Project# 1010446

15DRB-70275 MINOR - PRELIMINARY/ FINAL PLAT APPROVAL

**CITY OF ALBUQUERQUE
PLANNING DEPARTMENT
August 12, 2015
DRB Comments**

RE: Lots 10-11, Block 38, Parkland Hills Addition

PLAT OF
 LOT 10-A, BLOCK 38
 PARKLAND HILLS ADDITION
 BEING A REPLAT OF LOTS 10 & 11, BLOCK 38
 PARKLAND HILLS ADDITION
 SECTION 26, T. 10 N., R. 3 E., N.M.P.M., CITY OF
 ALBUQUERQUE, BERNALILLO COUNTY, NEW MEXICO
 MAY, 2015

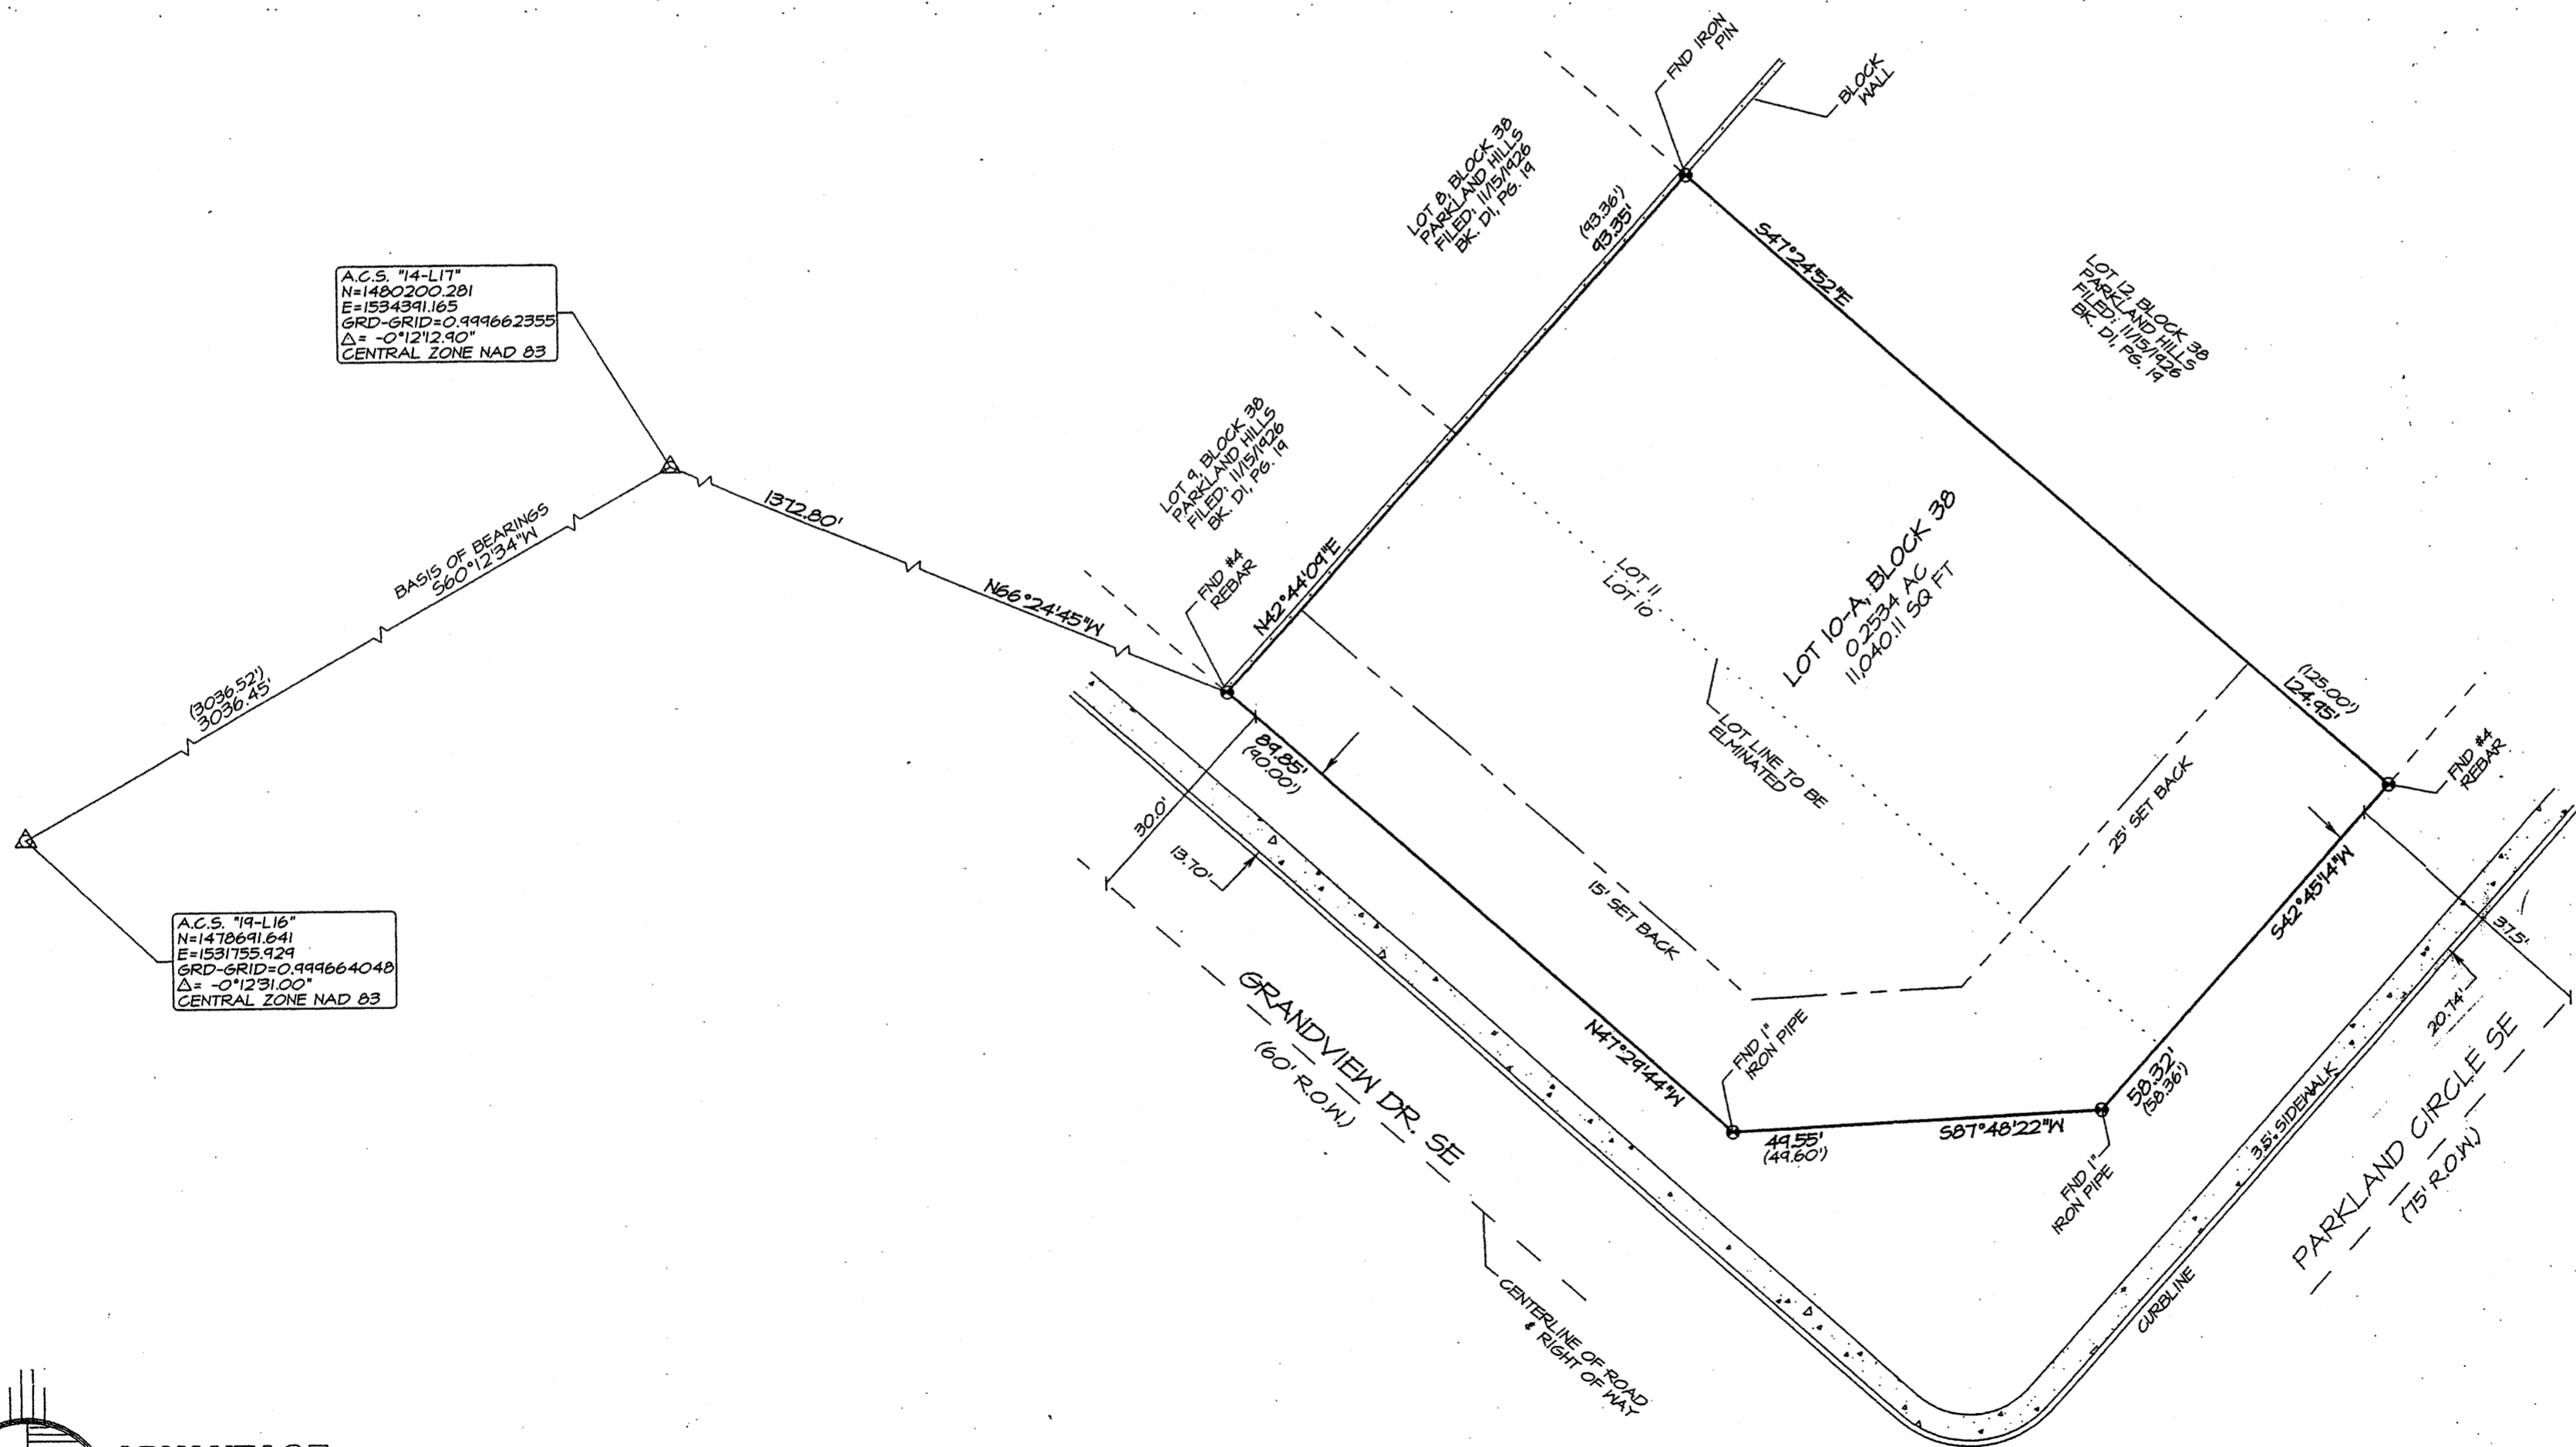
The Graphic/ Drafting Standards of the Development Process Manual/ DPM do not allow for the curb/ gutter/ sidewalk to be part of the line work on Sheet 2; these need to be removed prior to filing.

PLAT OF
 LOT 10-A, BLOCK 38
 PARKLAND HILLS ADDITION
 BEING A REPLAT OF LOTS 10 & 11, BLOCK 38
 PARKLAND HILLS ADDITION
 SECTION 26, T. 10 N., R. 3 E., N.M.P.M., CITY OF
 ALBUQUERQUE, BERNALILLO COUNTY, NEW MEXICO.
 APRIL, 2015

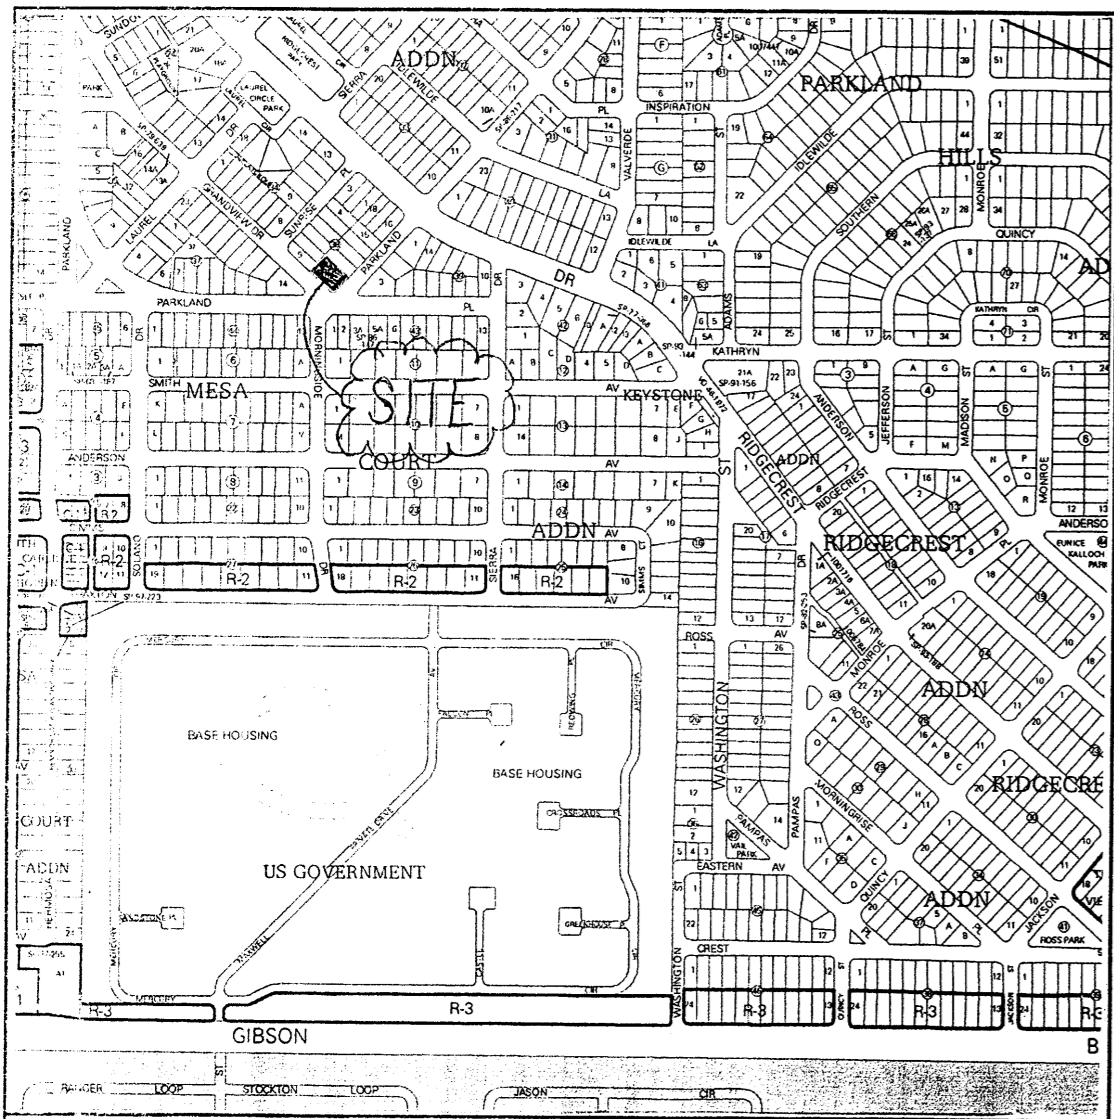
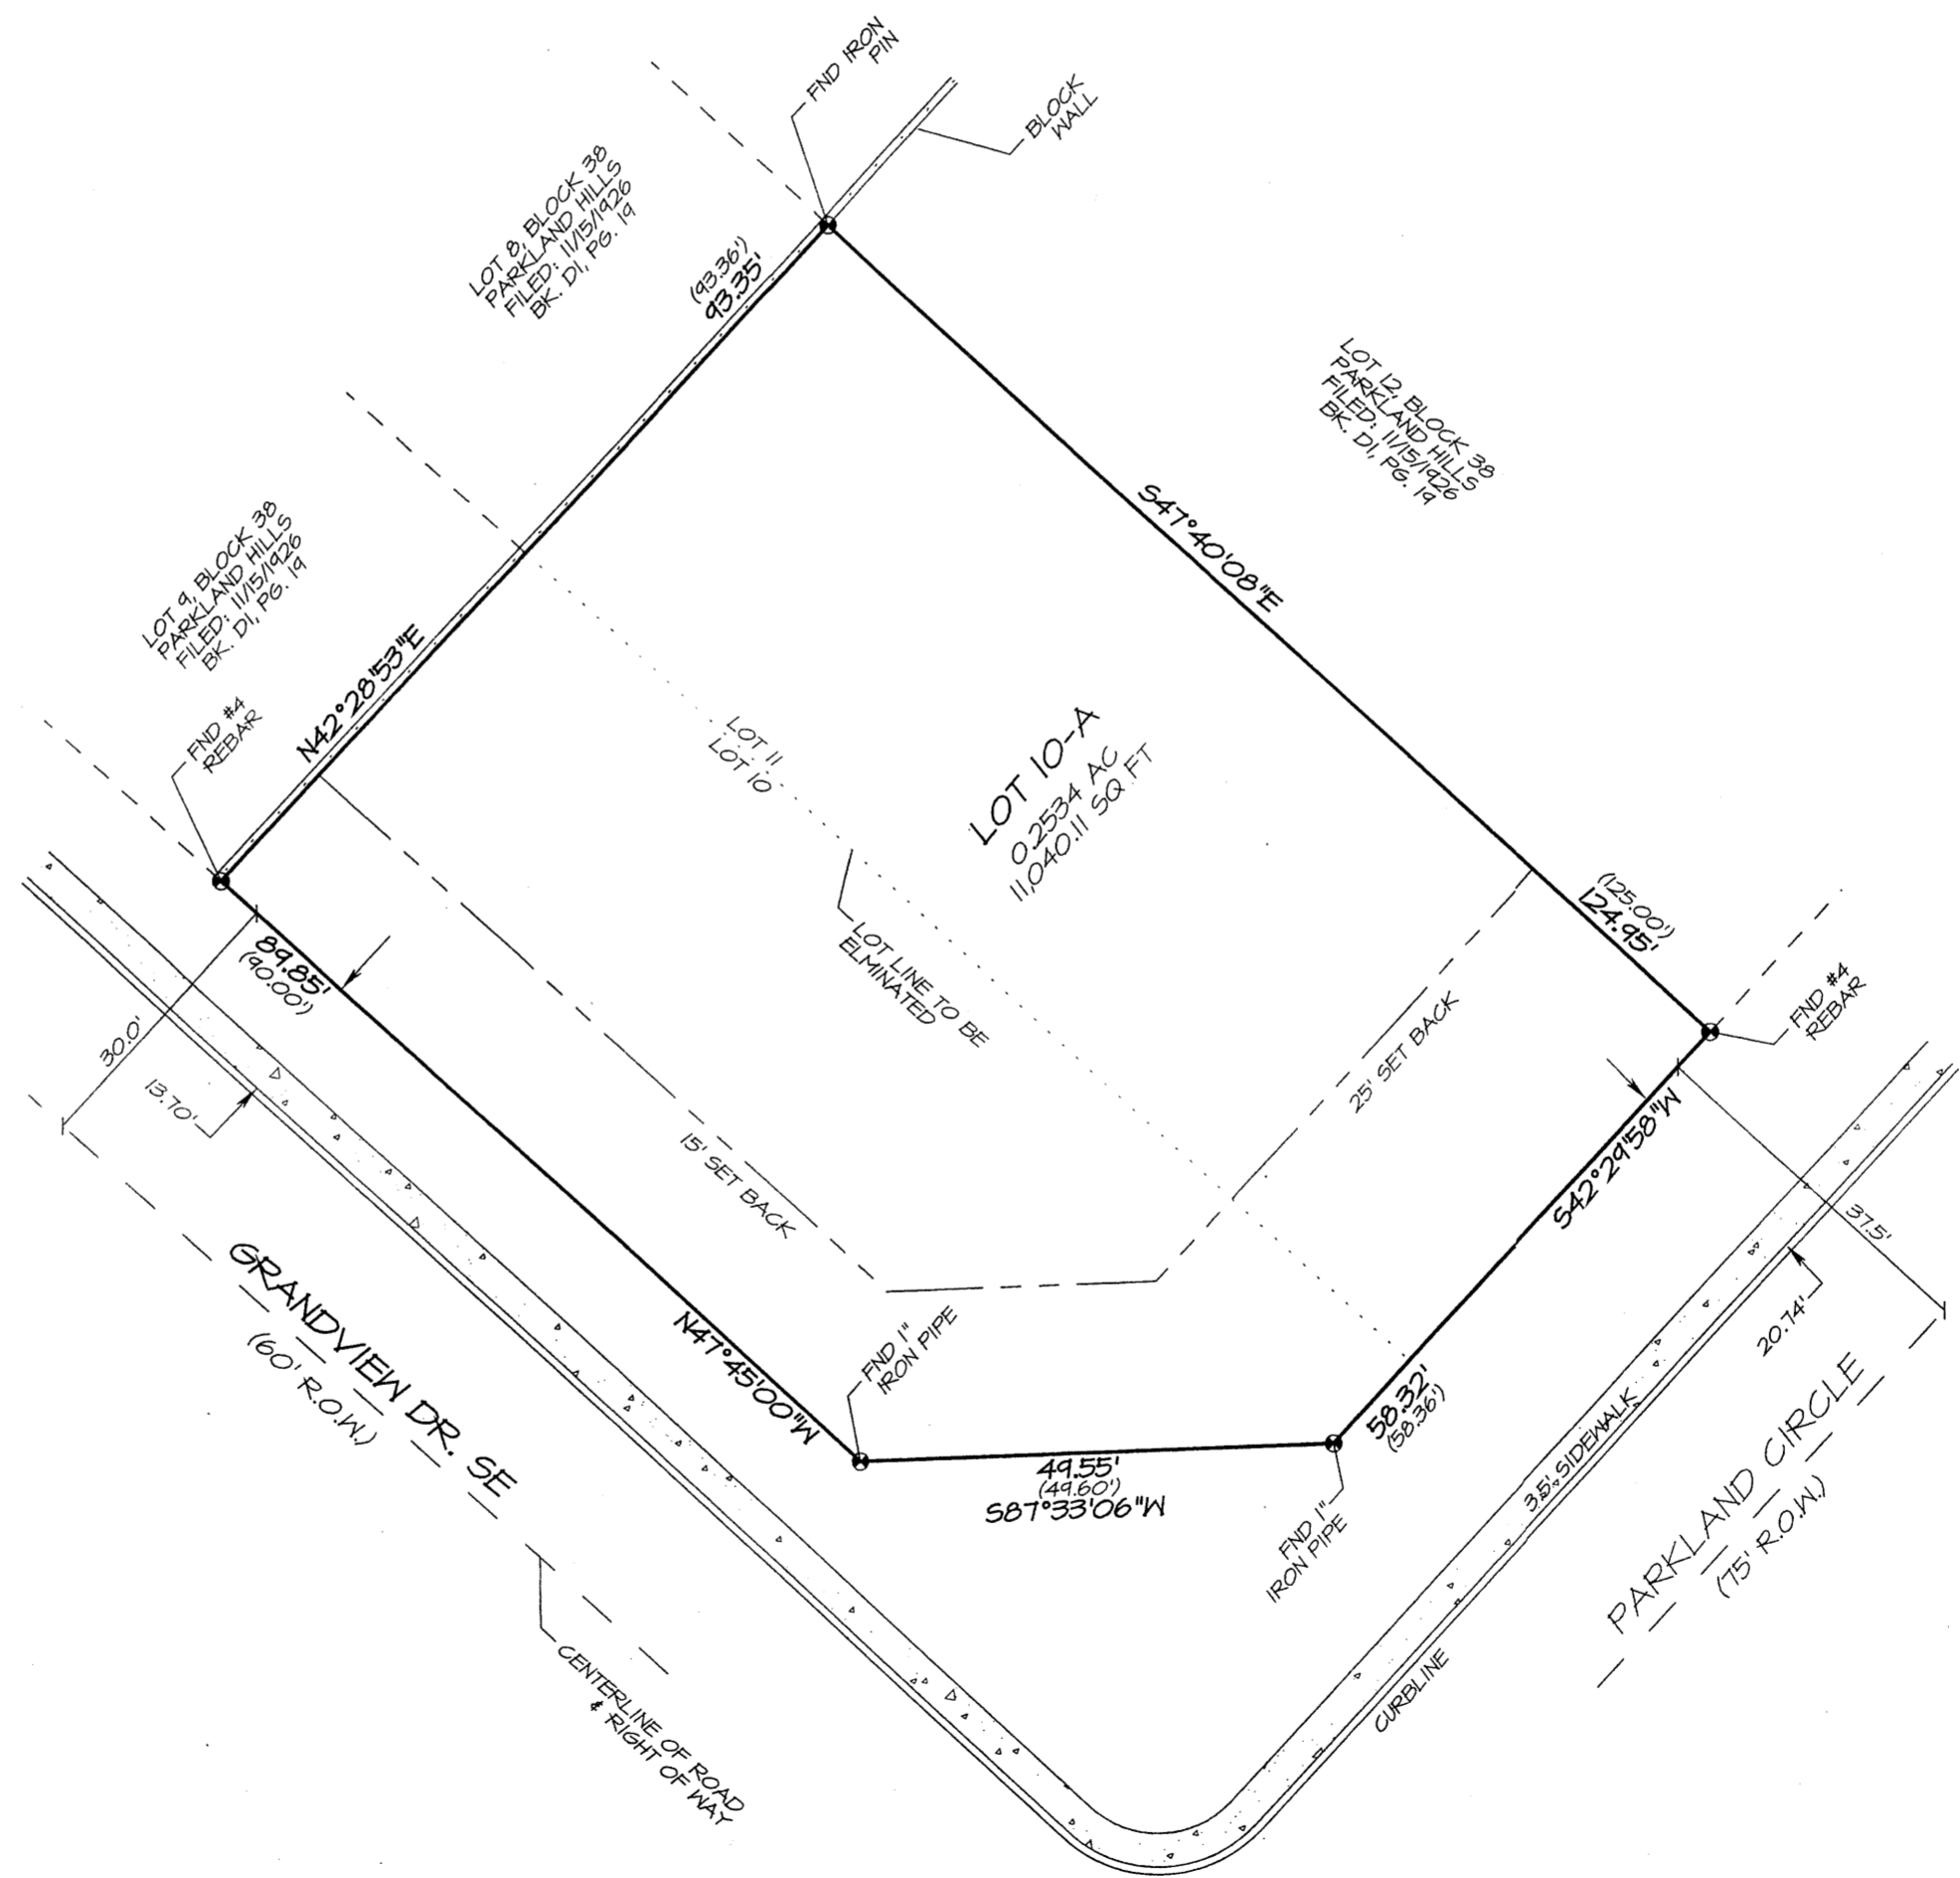
Please remove reference to County Case No.'s for City approval; also please remove Subdivision Data/ Zoning Note No. 9 for Final Plat.
